December 10, 2018

RE: **Juan Tabo Hills Park**
Grading and Drainage Plan for GP, SO-19, and BP- Approved
Engineer's Stamp Date: 12/5/2018 (M22D017A)

Project Title: Juan Tabo Hills Park Phase 1 Building Permit #: _____ Hydrology File #: M22D017A

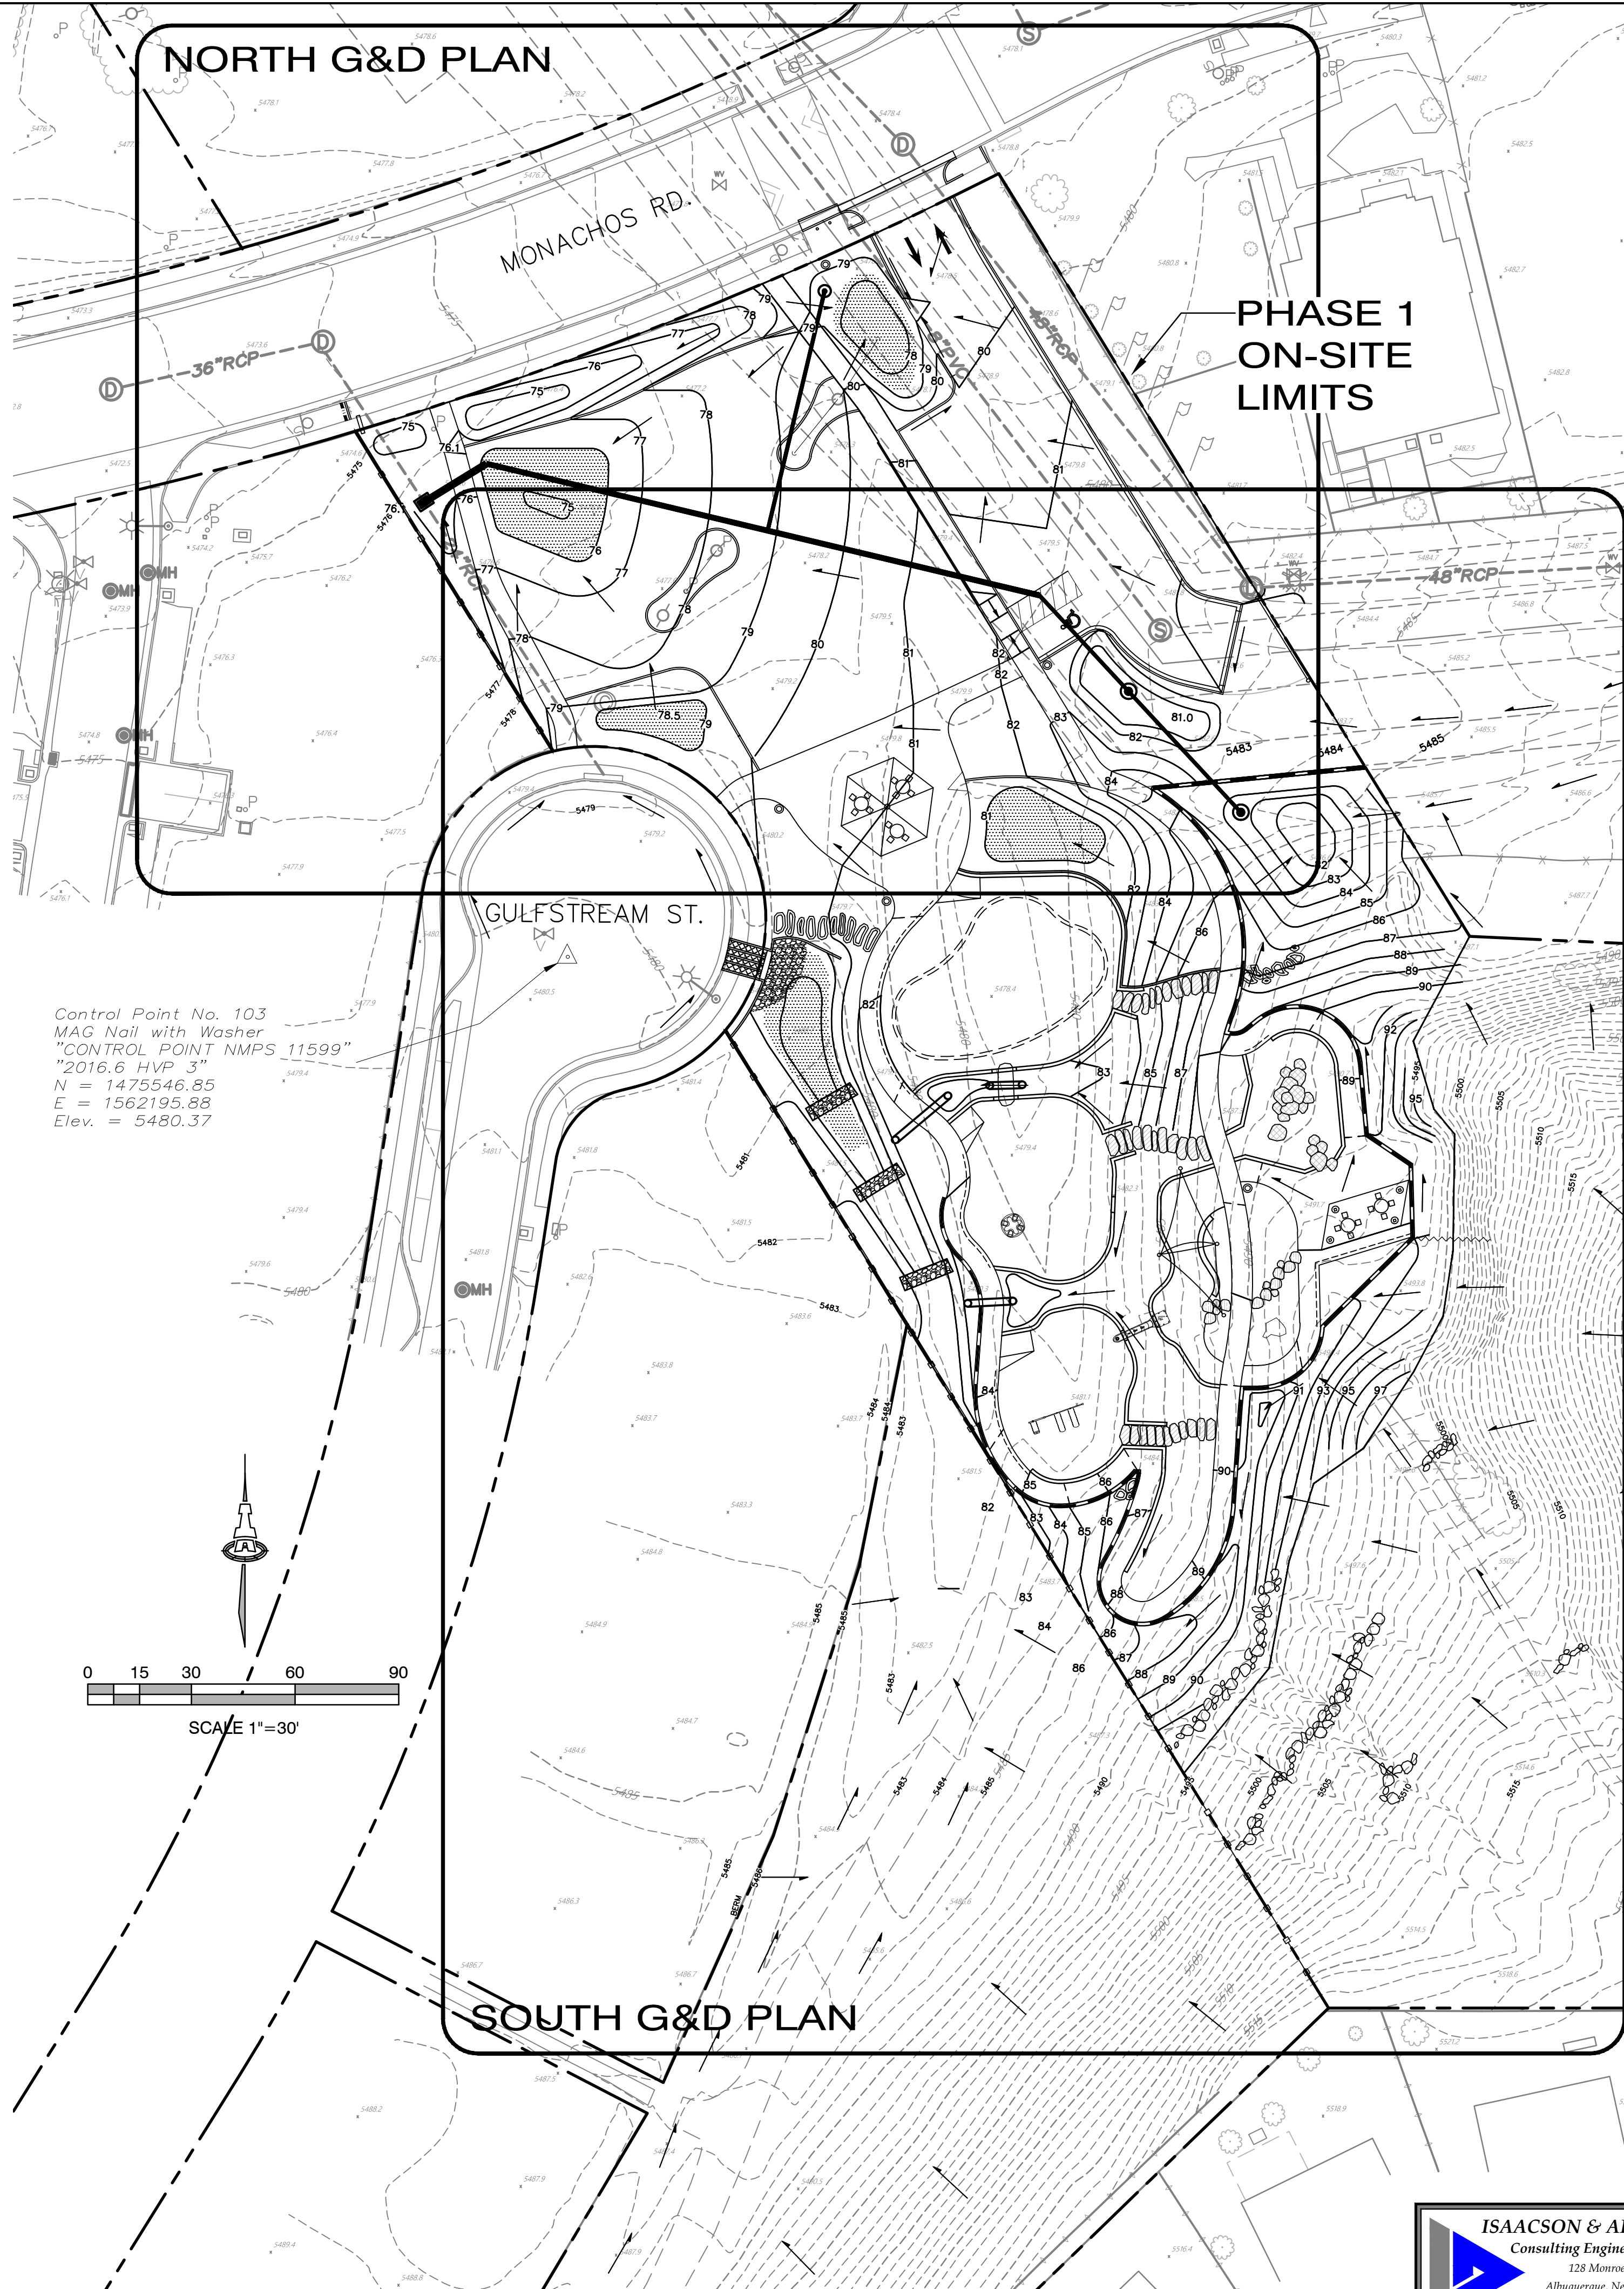
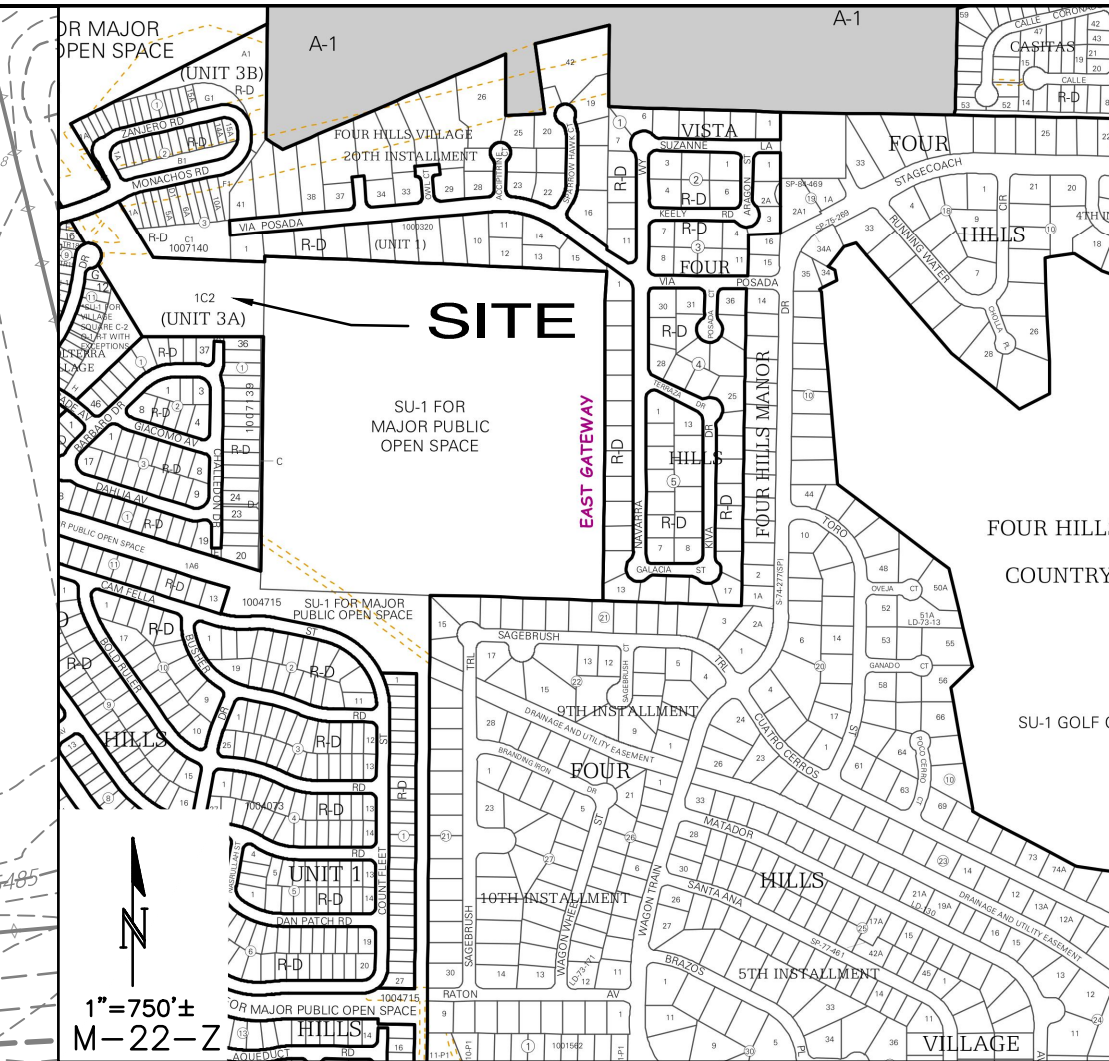
Based upon the information provided in the submittal received on 12/5/2018 the above-referenced plan is approved for Grading Permit, SO-19 Permit, and Building Permit. Please include a Copy of this G&D Plan in the plan sets for Building Permit. Please remember that the Public Drainage easements on the existing 48"- 66" storm drain on the east side of the site (25' min width centered on the pipe) both north and south of Monachos Rd. still need to be granted.
